2024/0141

8 Chapel Street, Ardsley, Barnsley, S71 5AY

Single storey front extension to dwelling.

Drawing Title **SITE PLANS**

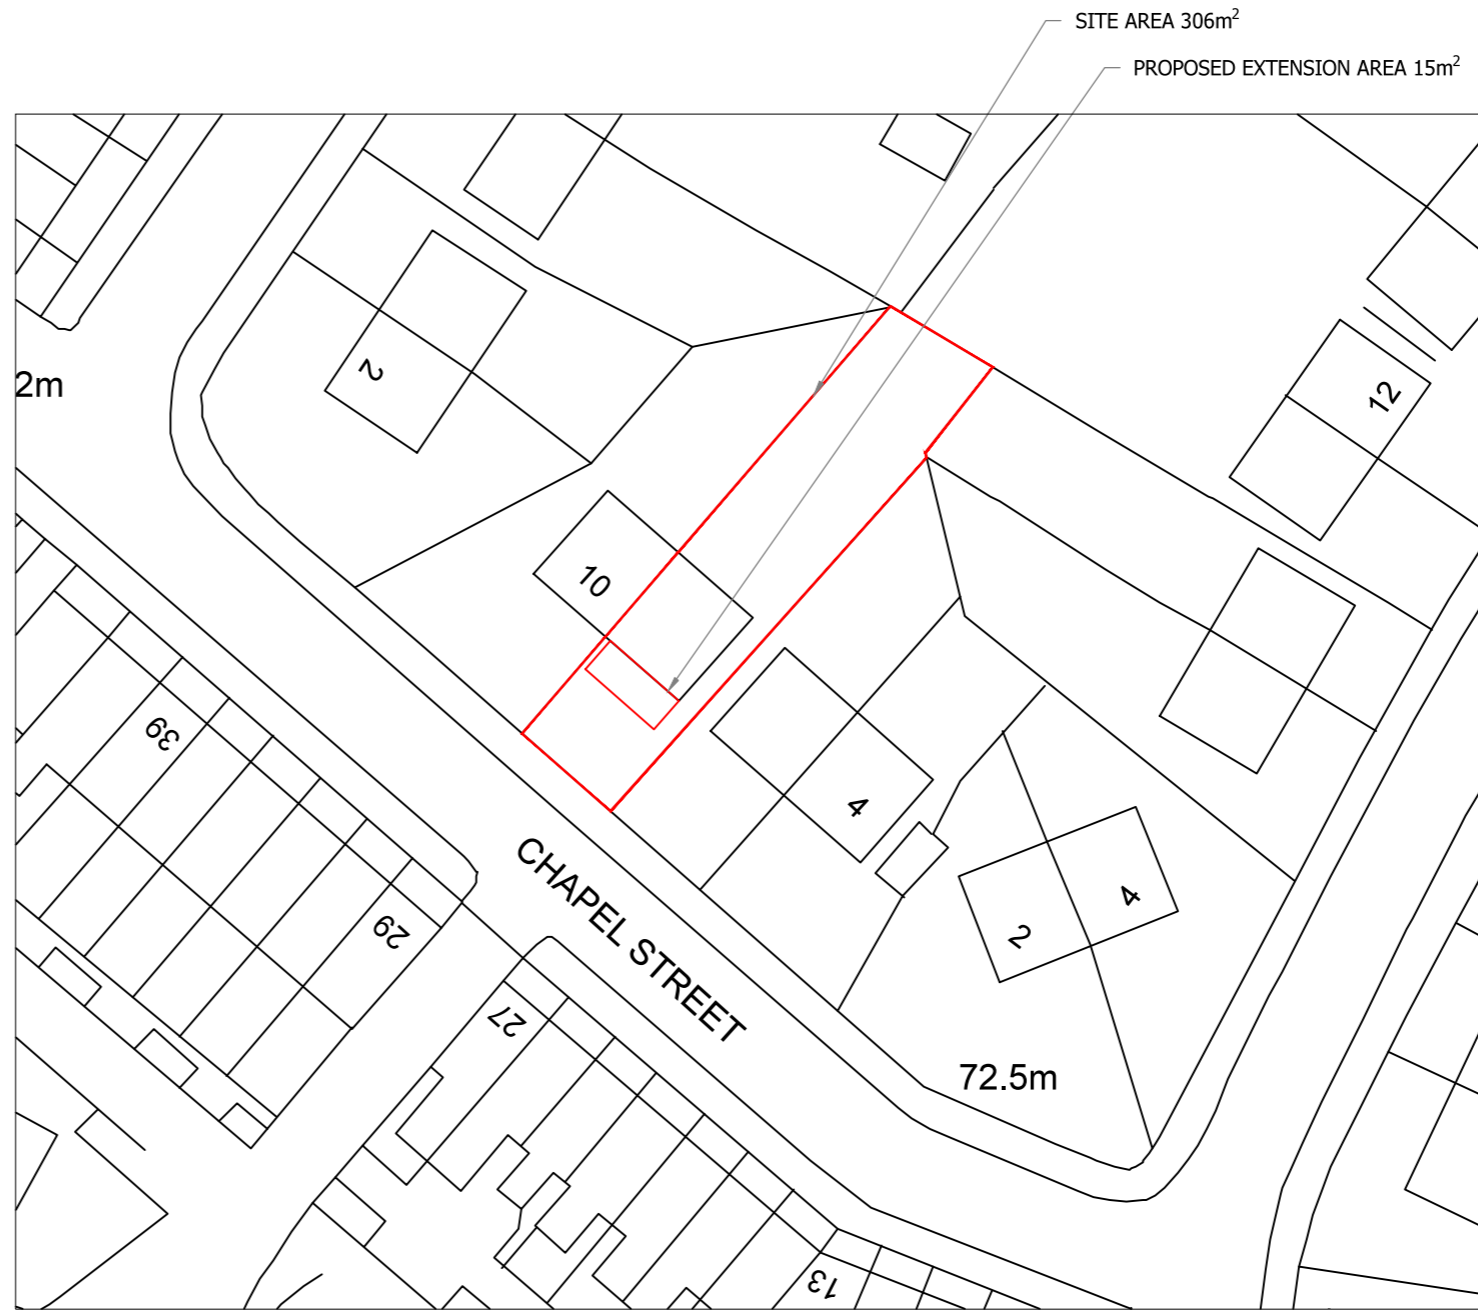
The proposal would increase the living space of the dwelling but would not increase the number of bedrooms. It is acknowledged that existing parking arrangements to the front of the dwelling could be impeded slightly. However, sufficient space would be retained to accommodate a minimum of two off-street parking spaces, in compliance with the parking SPD.

Drawing Title **PROPOSED ELEVATIONS**

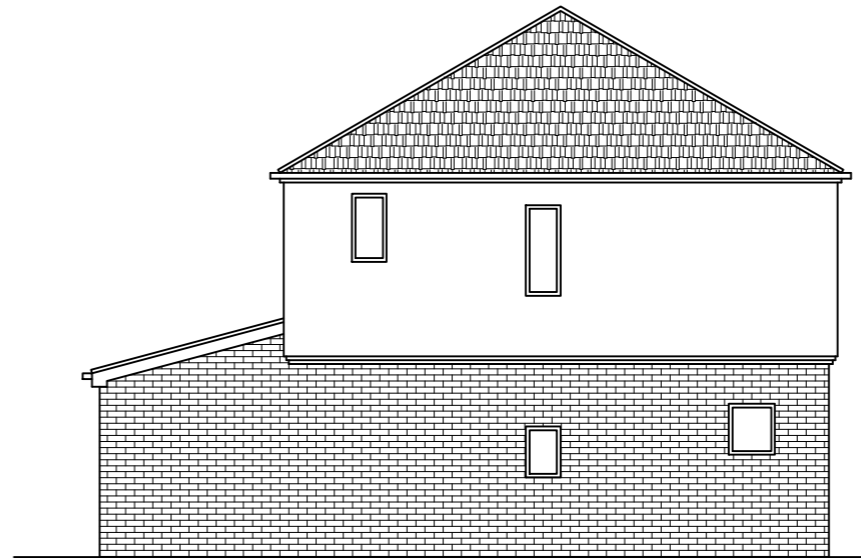
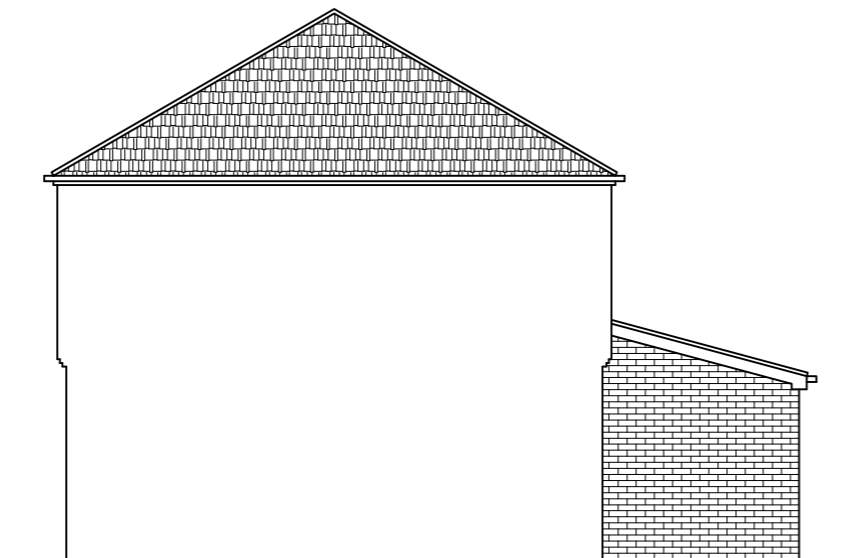
The proposed extension would project from the front elevation of the dwelling by approximately 2.5 metres with a width of approximately 6 metres. The extension would adopt a monopitched roof with an approximate eaves and ridge height of 2.4 metres and 3.2 metres respectively. The extension would be constructed of matching external materials, including brickwork and tiling.

In this instance, the proposed extension would provide additional space to a front living room with an integral porch to the front door. The extension would be of a single storey and would adopt a sympathetic form and features, including a pitched roof type and matching external materials. Similar forms of development can be seen in the street scene.

Drawing Title **PROPOSED PLANS**

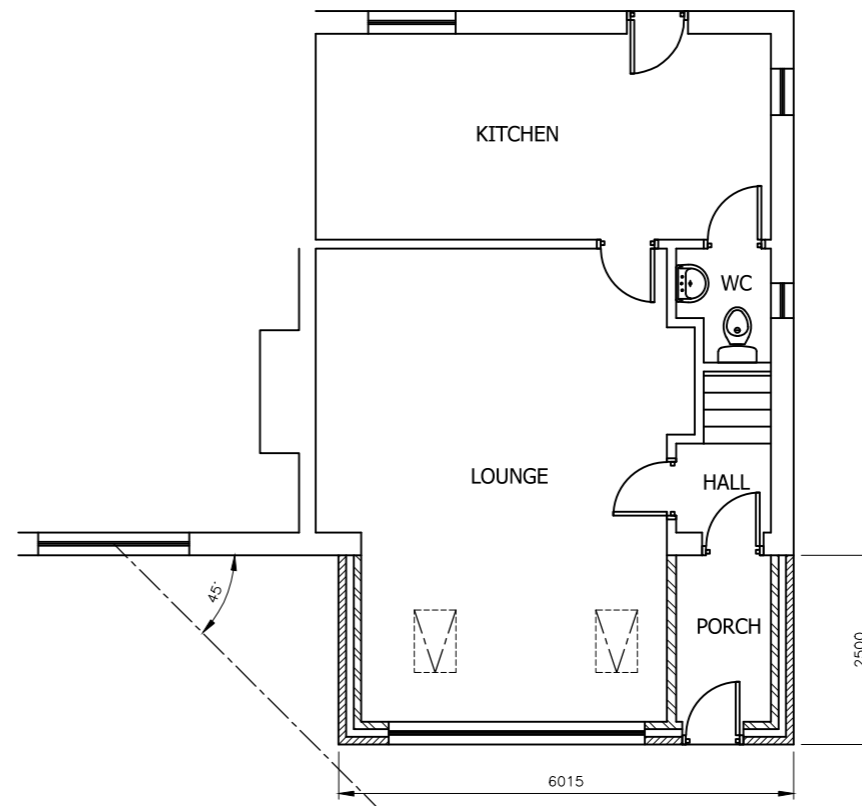
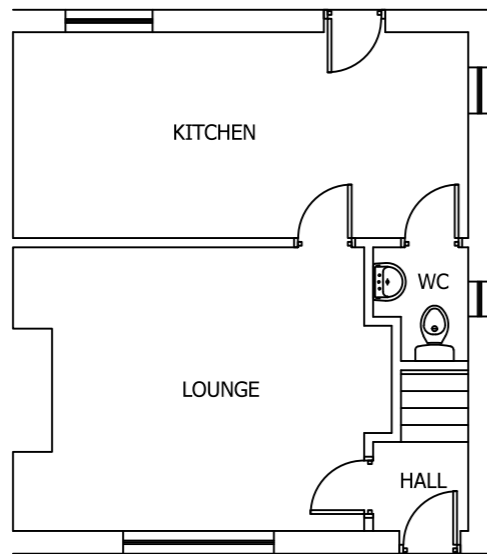
The proposed extension would be located to the north-west of adjacent property, 6 Chapel Street, and to the south-east of adjoining property, 10 Chapel Street. Extensions located to the south, south-east and south-west of neighbouring properties are generally considered to have a greater impact regarding overshadowing. Therefore, it is acknowledged that some overshadowing could occur. However, any potential impact is not considered to be significantly detrimental, especially as the extension would adopt a modest scale that would not exceed the 45-degree rule (which is applied to assess and limit the extent of overshadowing).

New windows would be limited to the front elevation of the extension and would face neighbouring properties opposite. As a general guide, windows to habitable rooms on an extended property should not be less than 21 metres from any other properties with habitable room windows. In this instance, the distance between ground floor habitable room windows would be reduced from approximately 21.7 metres to approximately 19.2 metres. As such, it is acknowledged that the proposal could result in increased loss of privacy. However, as the majority of the existing distance would be maintained, any potential impact is not considered to be significantly detrimental.
